WE STRONGLY OBJECT TO THE ITNABLE
PRECINCT DEVELOPMENT IN ITS CURRENT
FORM.

Re: Objections to Proposal to Redevelop Stabling DA 871/2010

We have strong objections to the proposed stable precinct development at Randwick Racecourse. Our chief concerns are;

ELEVATIONS - STABLE BLOCK
 STABLES & TRAINING FACILITIES
AJC RANDWICK RACECOURSE

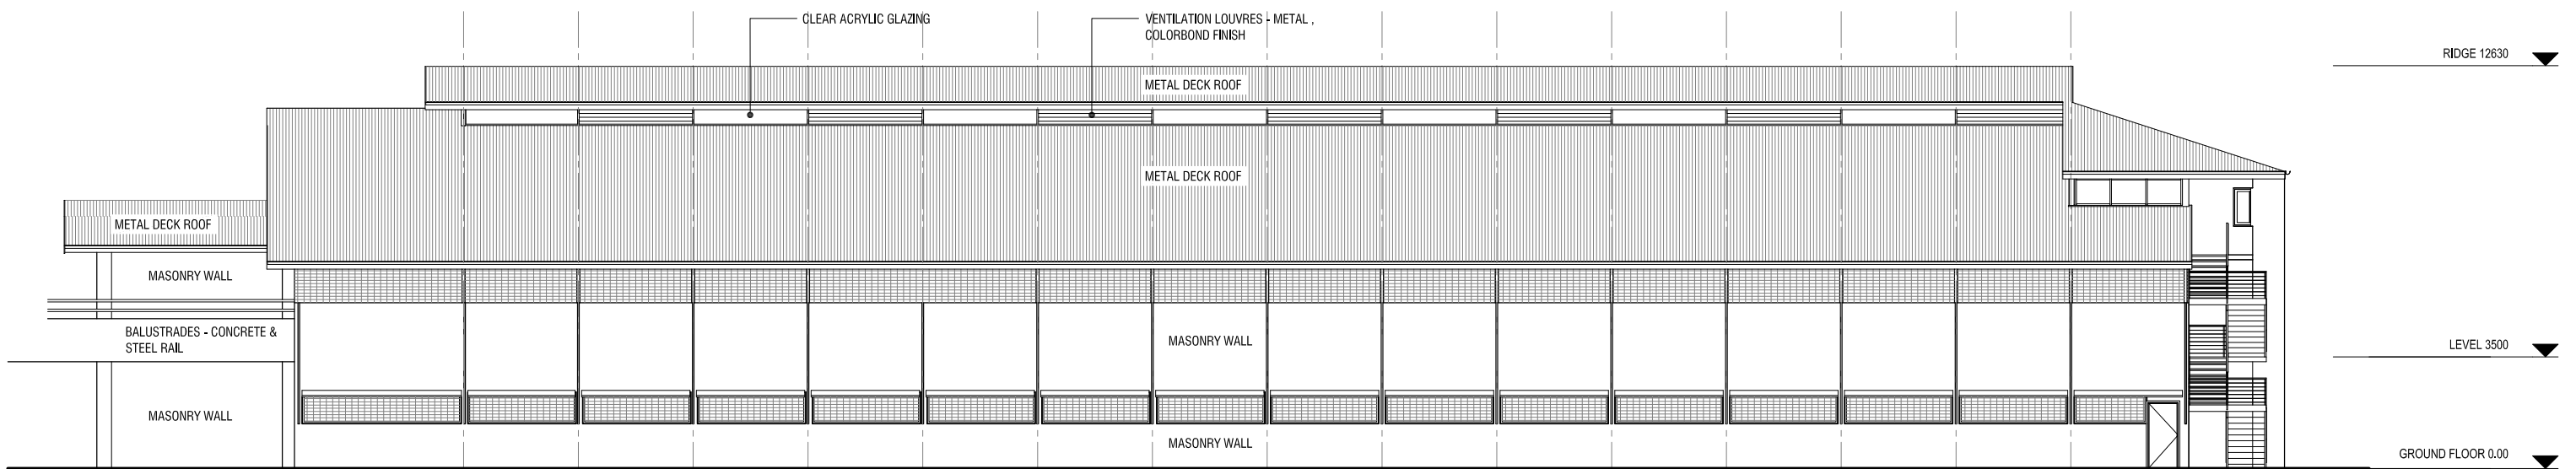
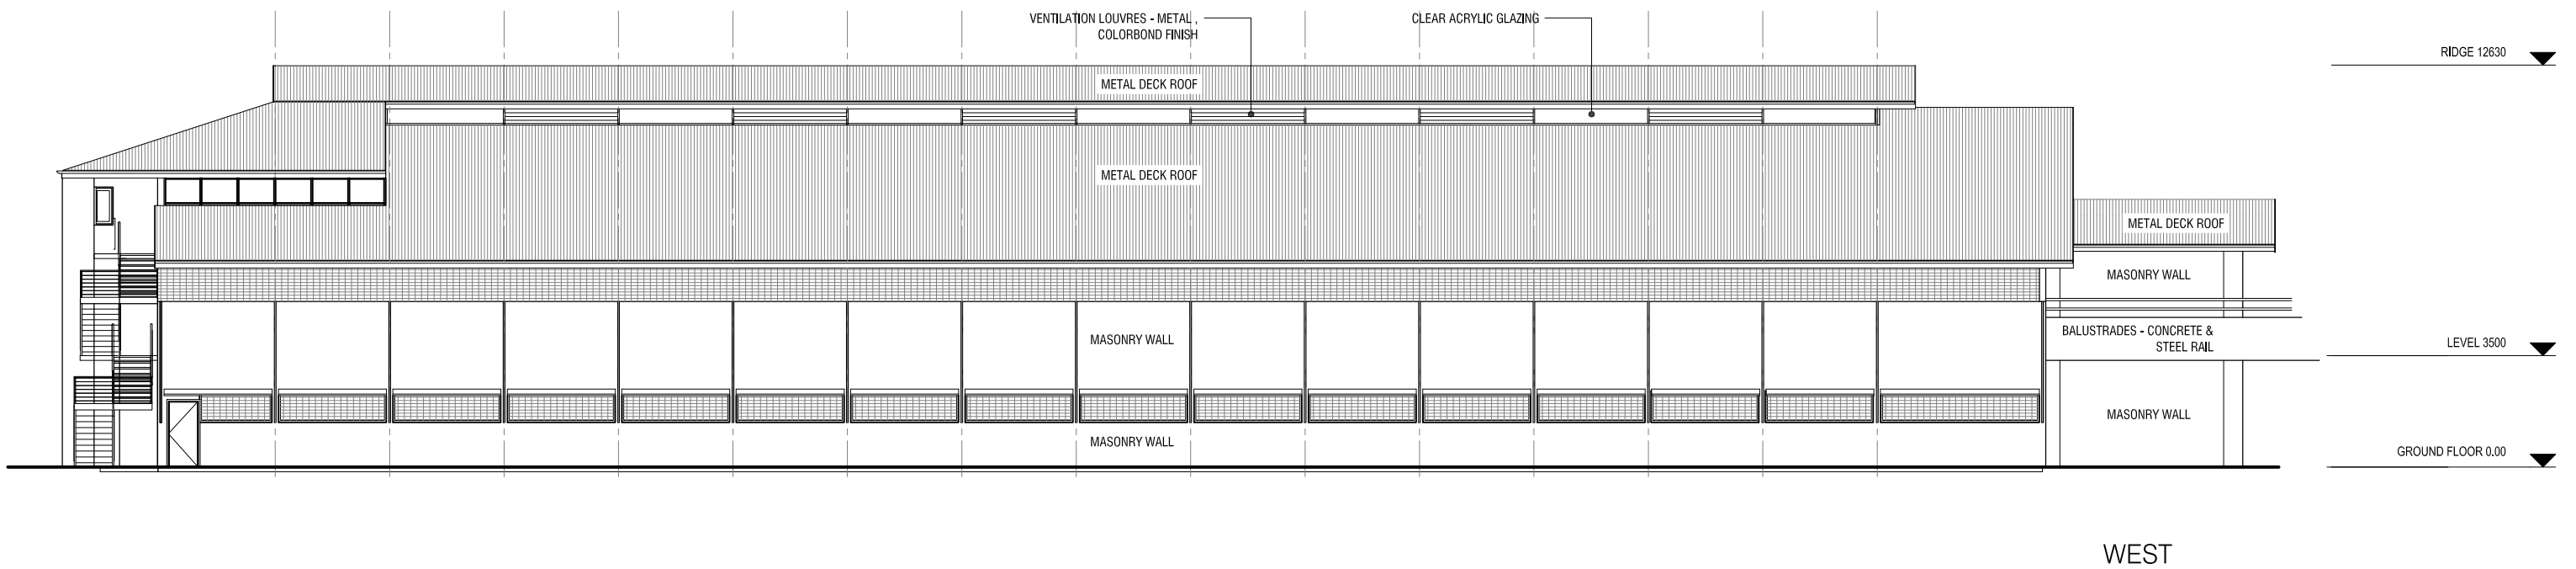
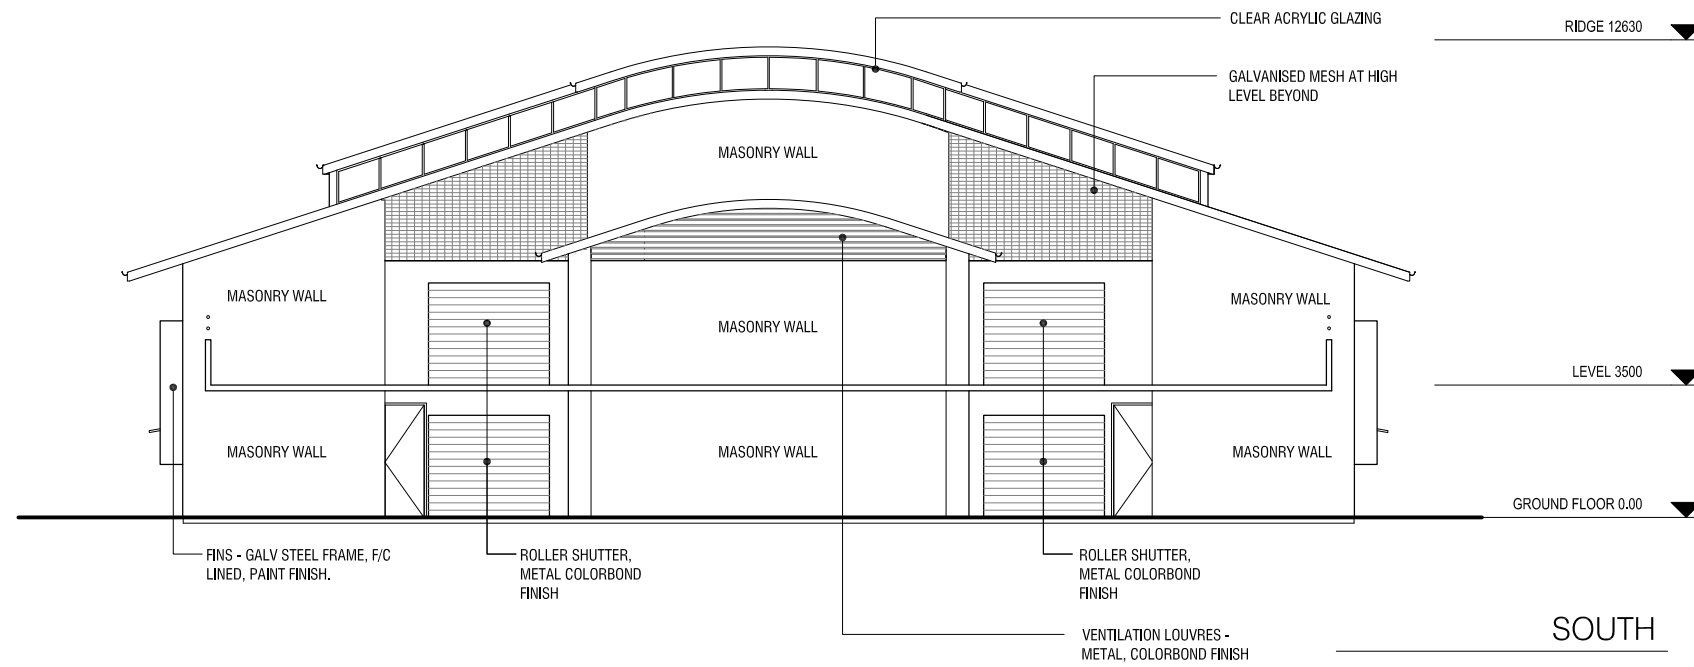
The description of the six barn style buildings as 'two' storey is misleading as they are the height equivalent of almost four residential storeys. Six four storey buildings along with a one hundred place plus carpark and at least a further twelve two storey buildings will result in a massive loss of outlook for nearby residents.

The proposed height of the development should be reduced.
